DOC24/901946

EPA Advice on Environmental Impact Statement

I am writing in response to your request for the Environment Protection Authority (EPA) to review the Environmental Impact Statement (EIS) for the proposed Tangaratta Feedmill (Application SSD-58801472) at 771 Wallamore Road, Wallamore NSW 2350

**STORMWATER CATCHMENT PLAN**

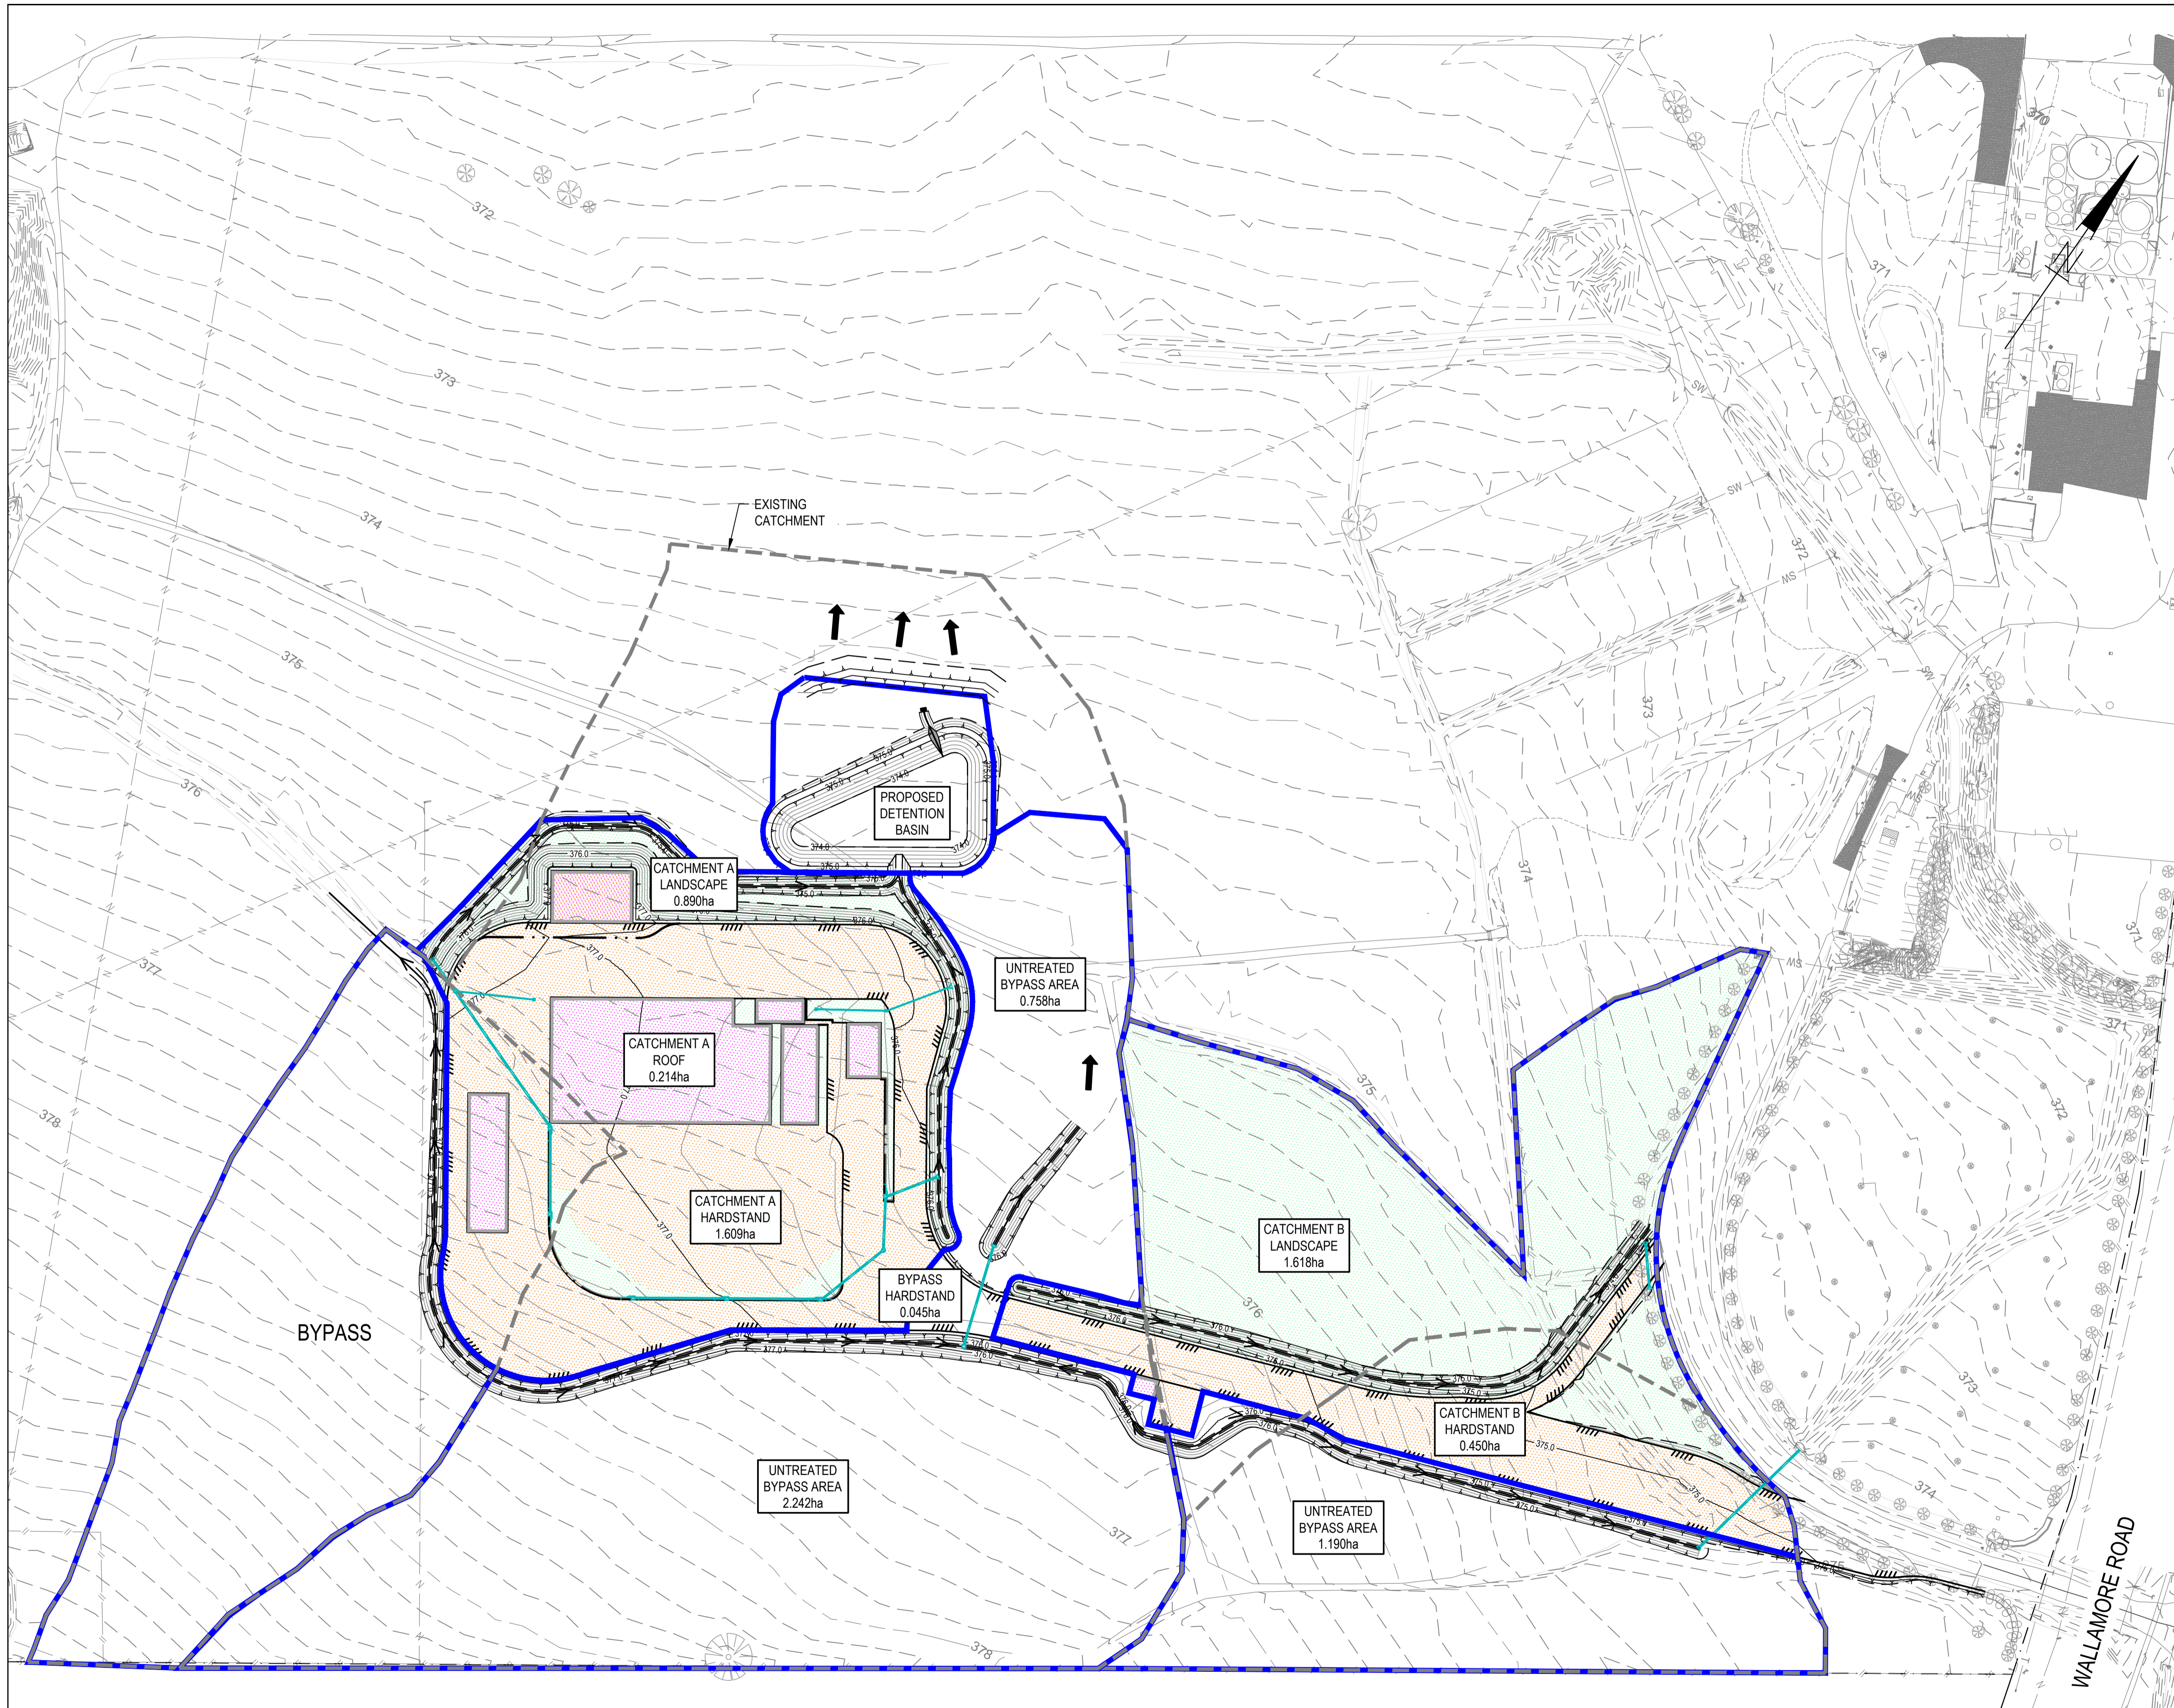
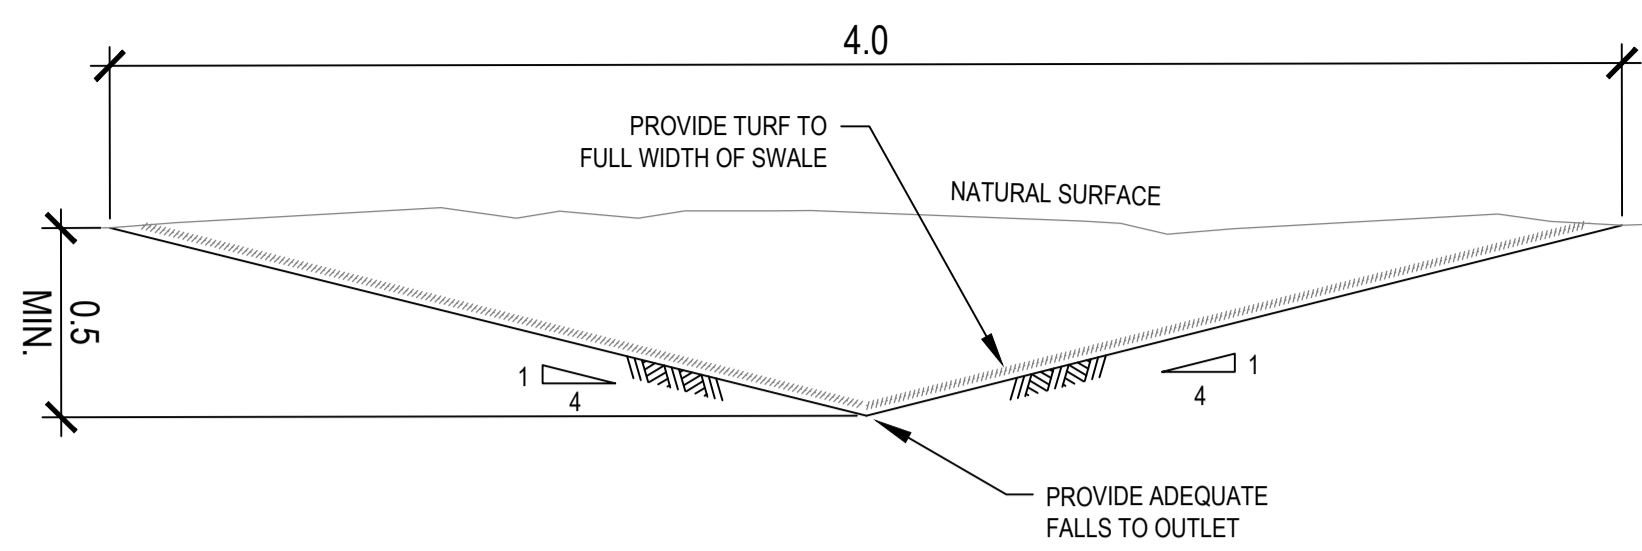
b. Music modelling

The MUSIC model was used to predict the performance of the proposed stormwater treatment train. The EIA states that: *"In the absence of specific Water Quality Objectives from Tamworth Regional Council, the industry standard pollutant reduction targets have been adopted."*

Tamworth Regional Council objectives and general urban stormwater objectives are not relevant to the site. As it will be a licensed premise, the relevant water quality objectives are set out in the NSW Water Quality Objectives framework which refers to ANZG (2018) water quality guidelines. MUSIC modelling involves targets for percentage reductions in pollutants which are not appropriate, for example:

The overflow frequency of the existing basins or proposed basins is not assessed. If there are pollutants from process inputs and outputs that may enter stormwater then the sizing of the basins may need to be larger to reduce the frequency of overflows and allow reuse options.

Appendix M lists the pollutants generated but does not indicate the sources of those pollutants, e.g. carparking clean hardstand vs areas that may include, for example, process water or run off from feed input stockpiles. Percentage reduction targets are not useful in this context.

The EPA recommends that the above issue be clarified.
